Application Ref:	3/2026/0006				Ribble Valley Borough Council <small>www.ribblevalley.gov.uk</small>
Date Inspected:	20/01/26	Site Notice:	20/01/26		
Officer:	LW				
DELEGATED ITEM FILE REPORT:					APPROVAL

Development Description:	Proposed single storey double garage to replace adjoining dilapidated workshop, coal store and timber garage. Conversion of existing garage into bedroom/ ensuite. Replacement of septic tank with sewage treatment plant.
Site Address/Location:	Monks Barton, Longsight Road, Langho, BB6 8AD.

7276 - P02E

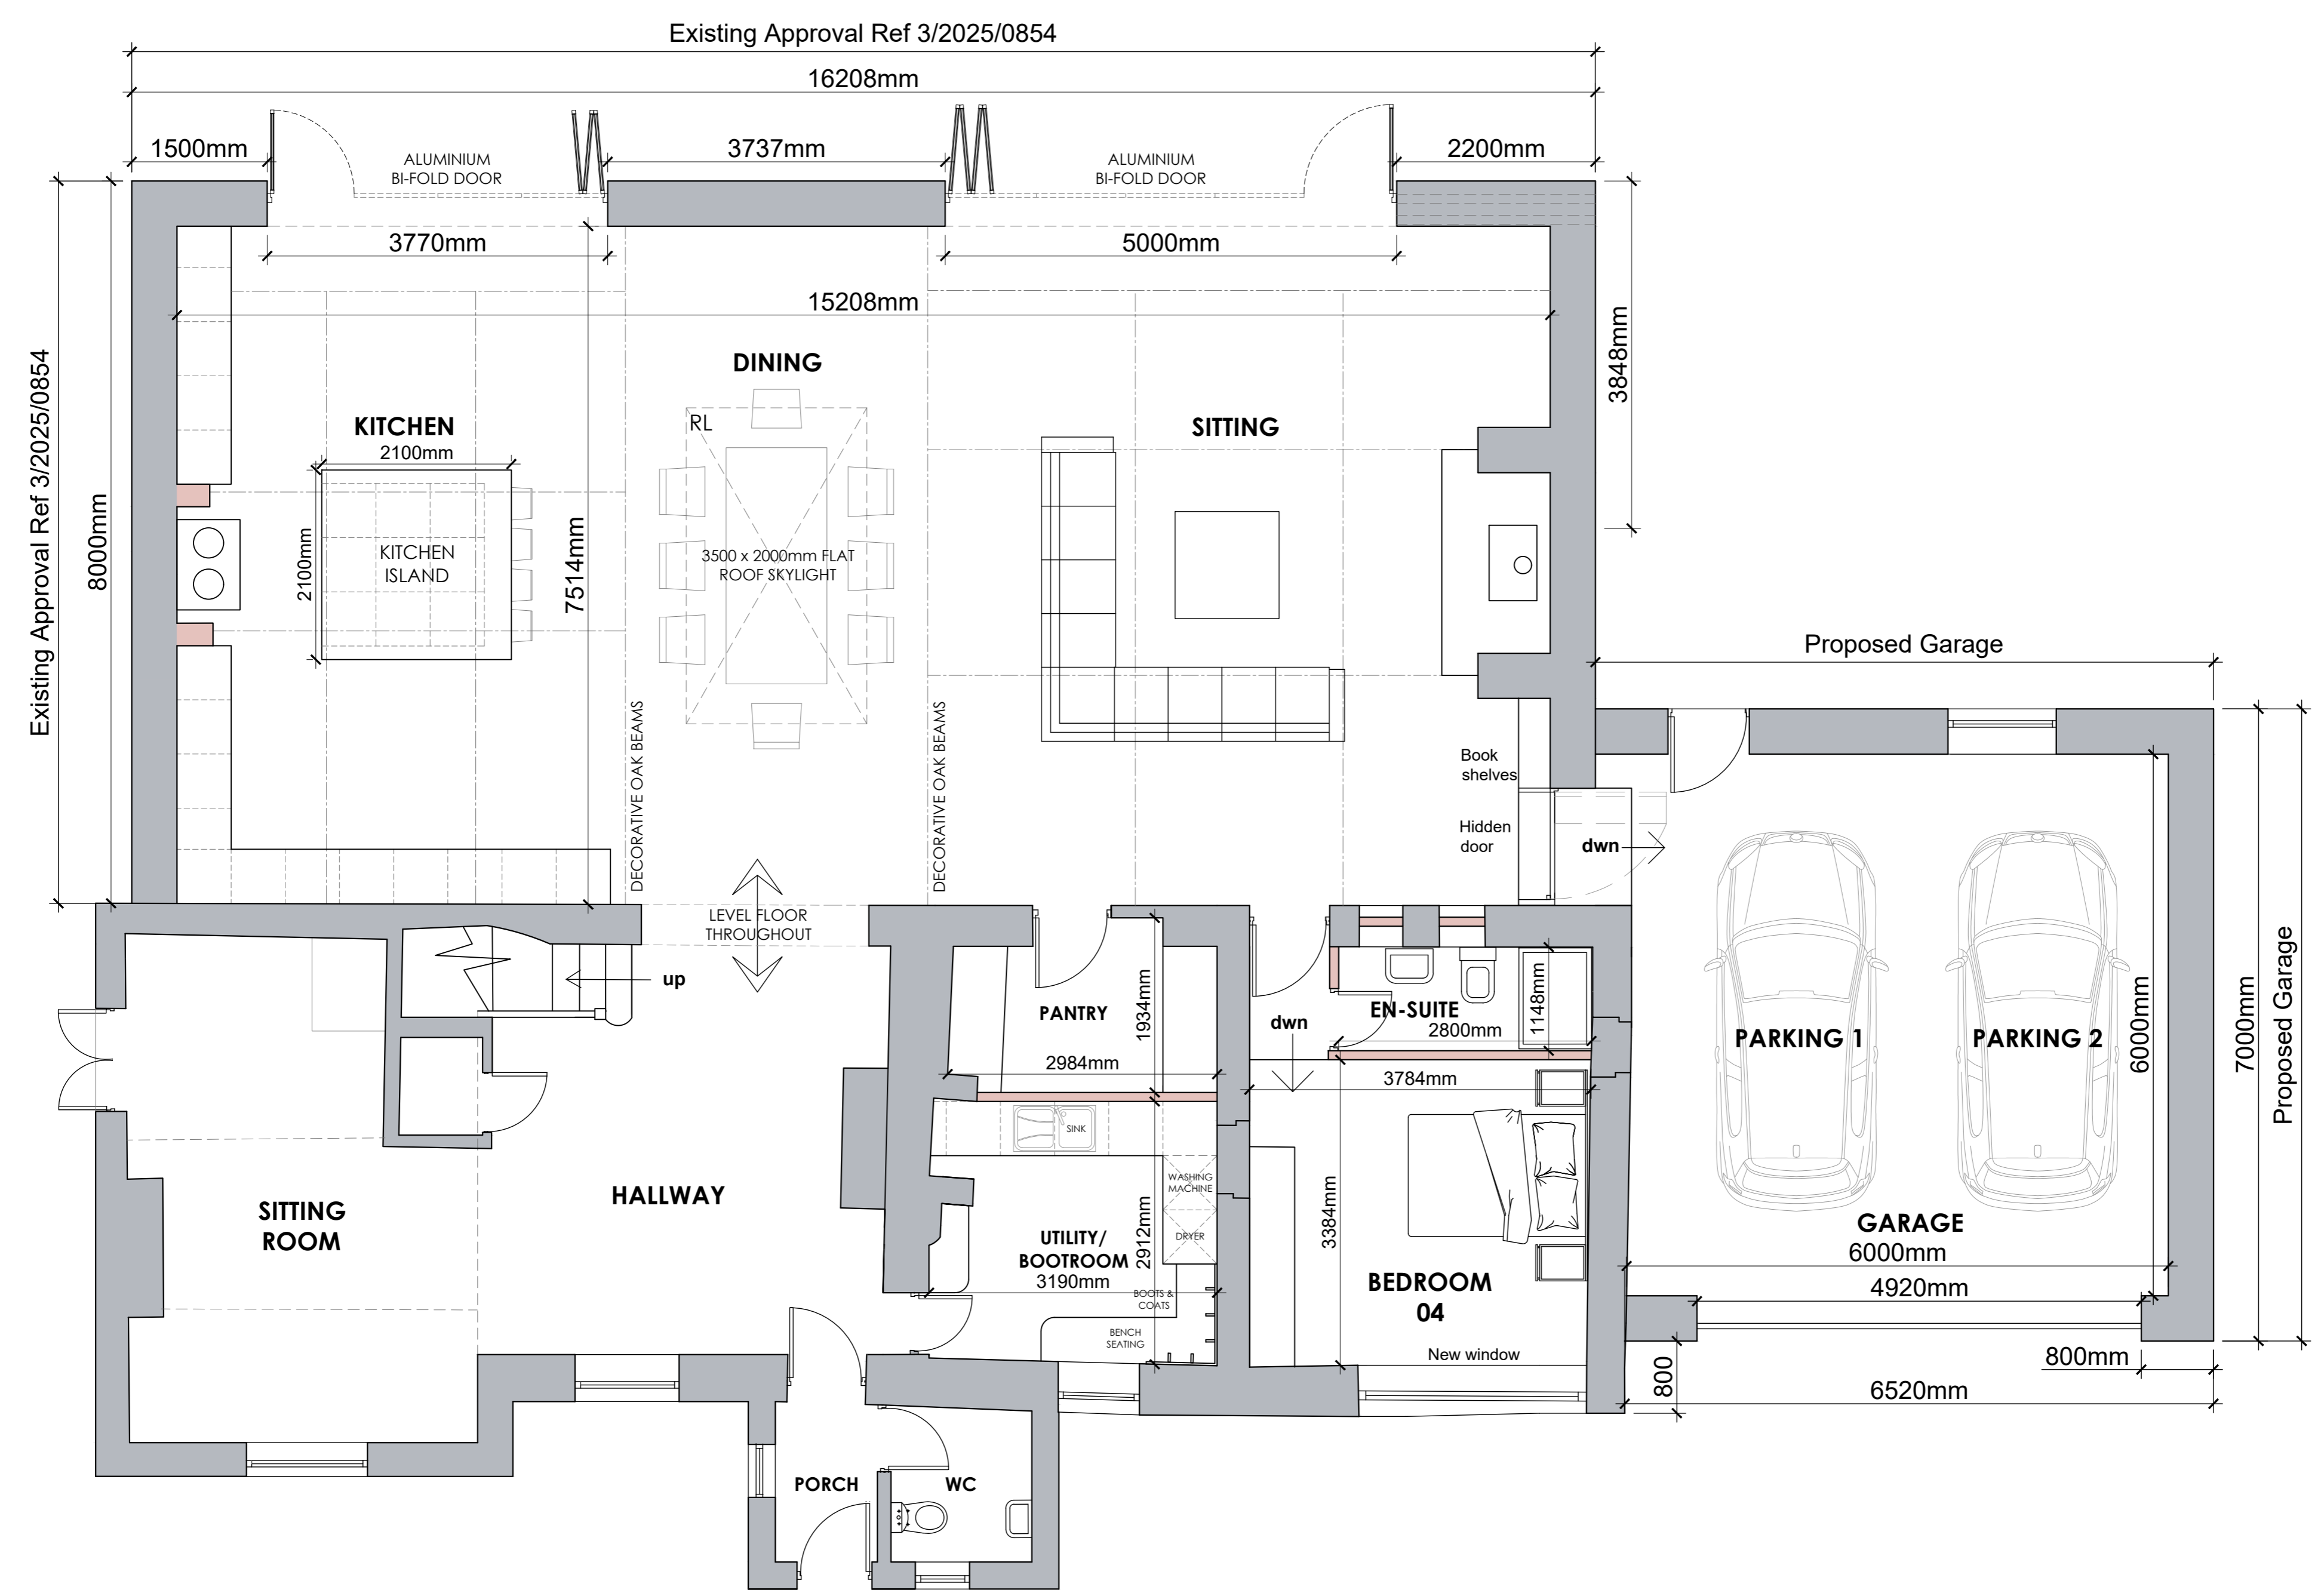
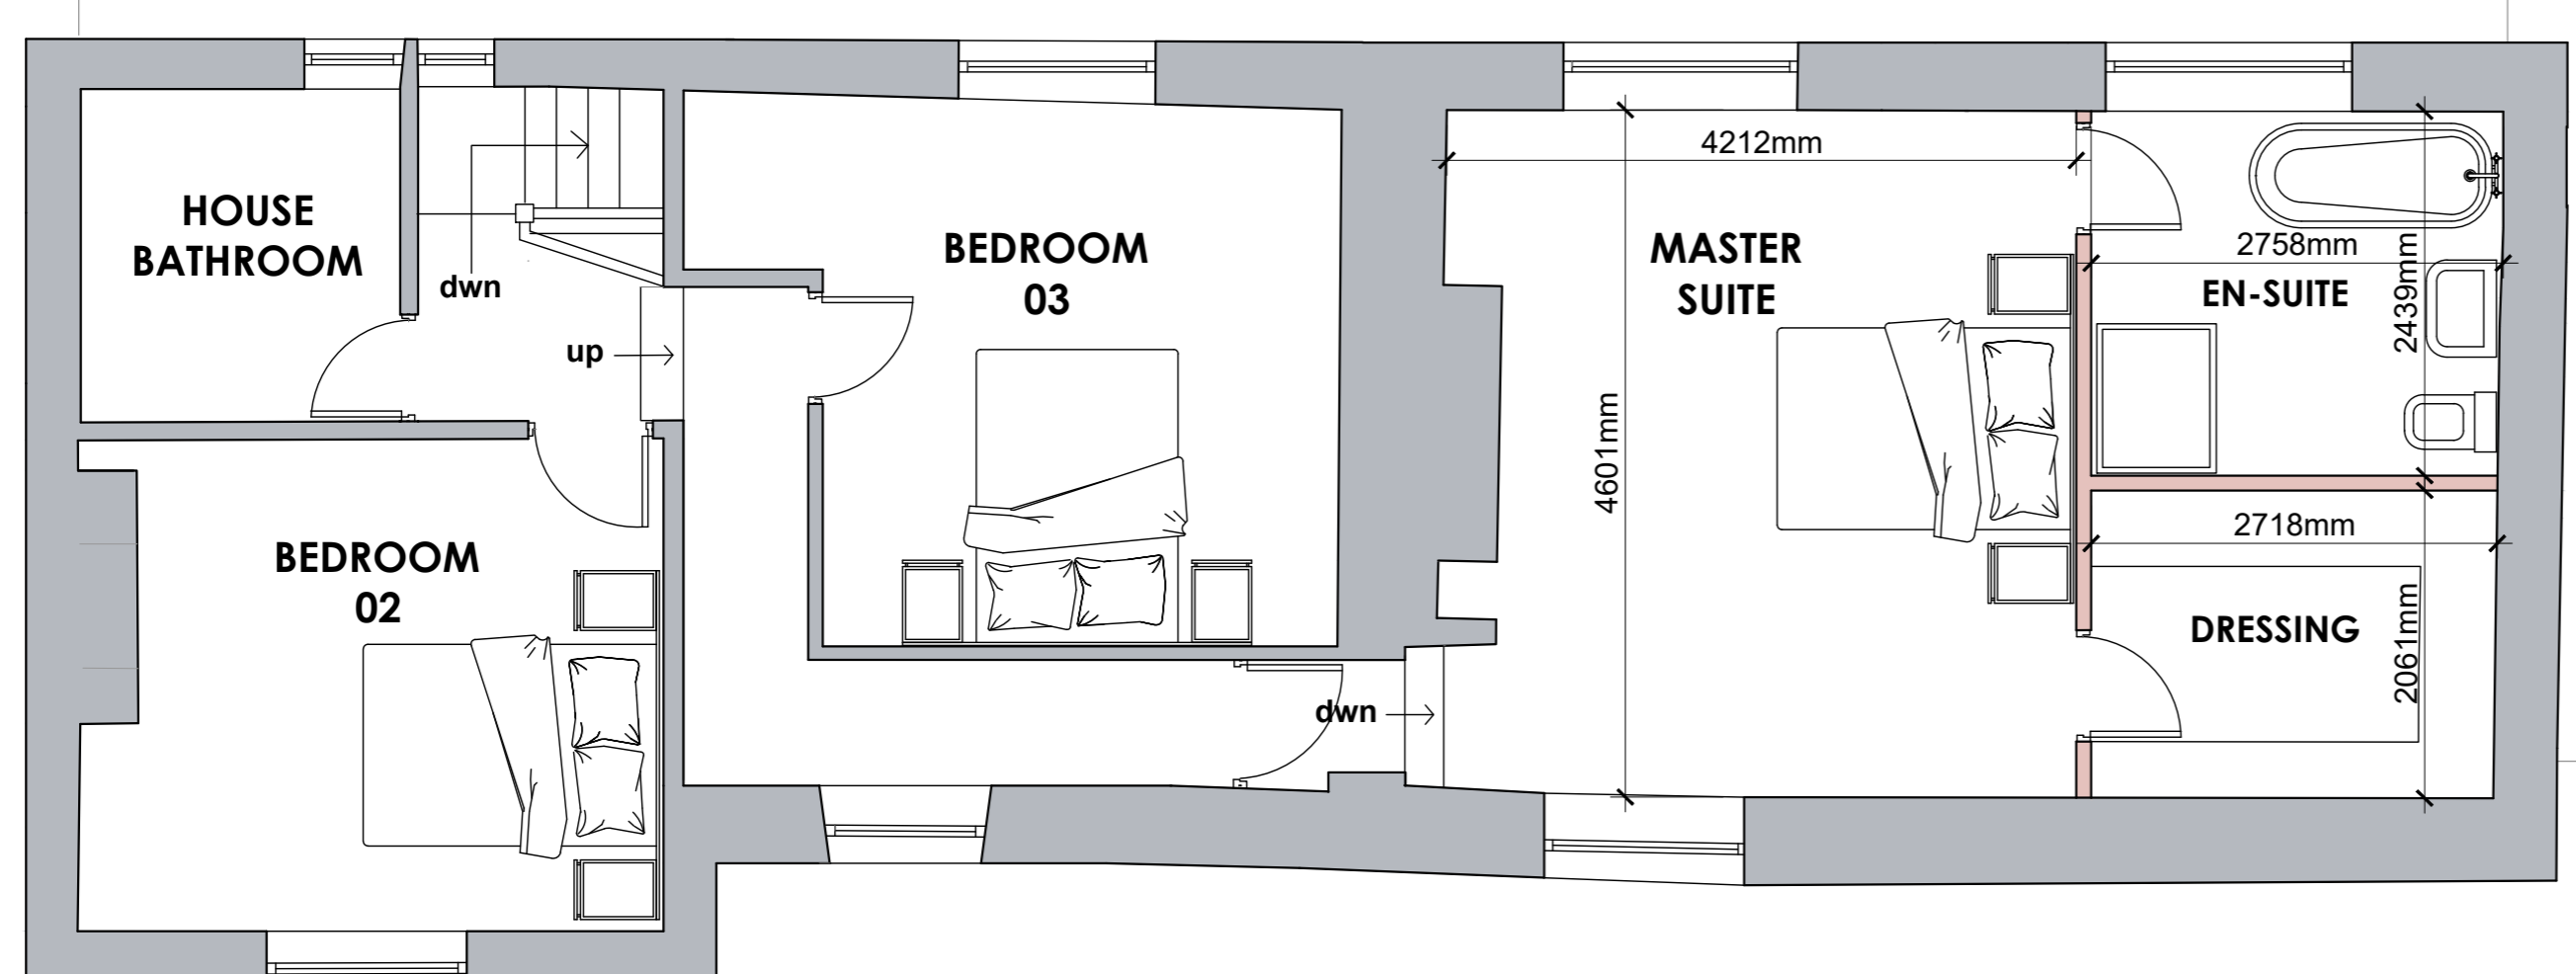
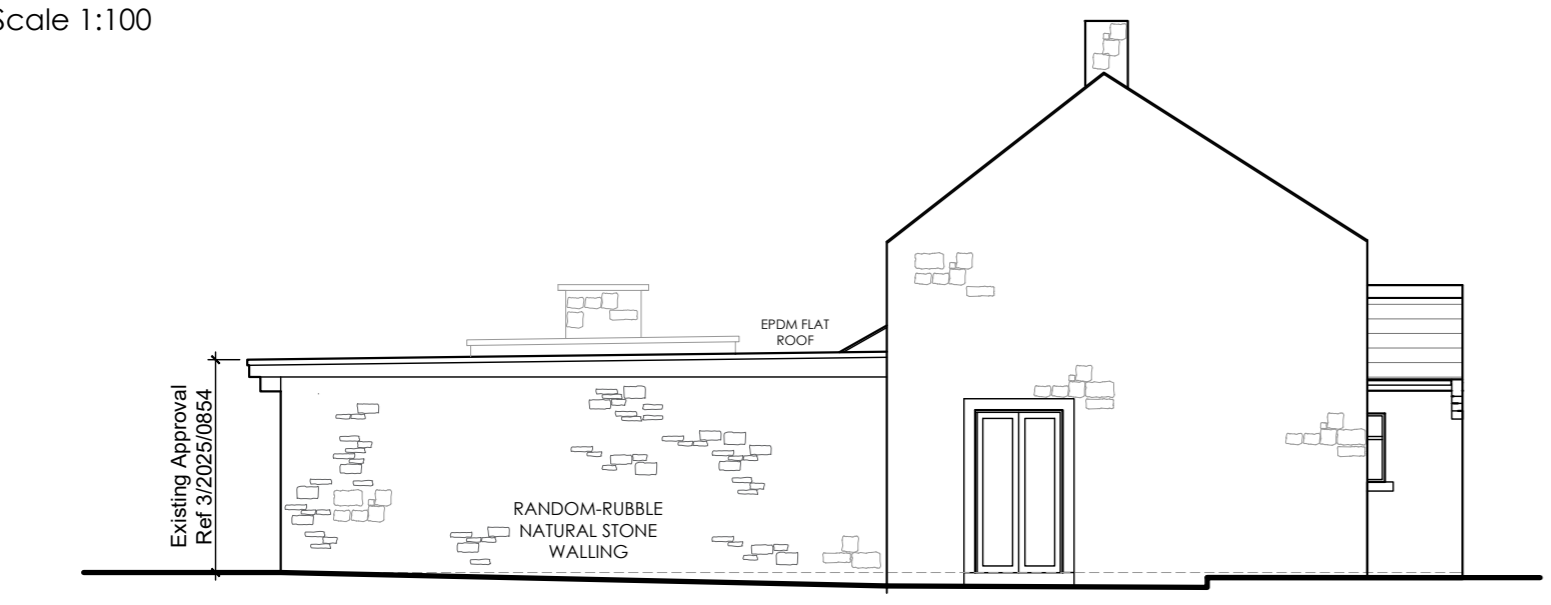
Following discussions with the Agent, the proposed garage has been reduced to a standard double garage size with a sideward projection of 6.52m and depth of 7m to accommodate a 6m-by-6m internal floorspace. A greater set back from the principal elevation of the dwellinghouse has also been incorporated. Whilst it is noted that the garage, together with the aforementioned rear extension, would still result in a substantial increase compared to the original built form of the property, when taking account of the size of the curtilage associated with the dwelling, it is not considered that the amended scheme would appear overly dominant or incongruous so as to warrant the refusal to grant planning consent for this reason alone. The proposed garage would be clearly set back from the principal elevation and down from the main ridgeline and the revised sideward projection of the addition would also not be

significant to an unacceptable degree when read in context with the existing built form, insofar that it would equate to less than half the width of the main dwelling.
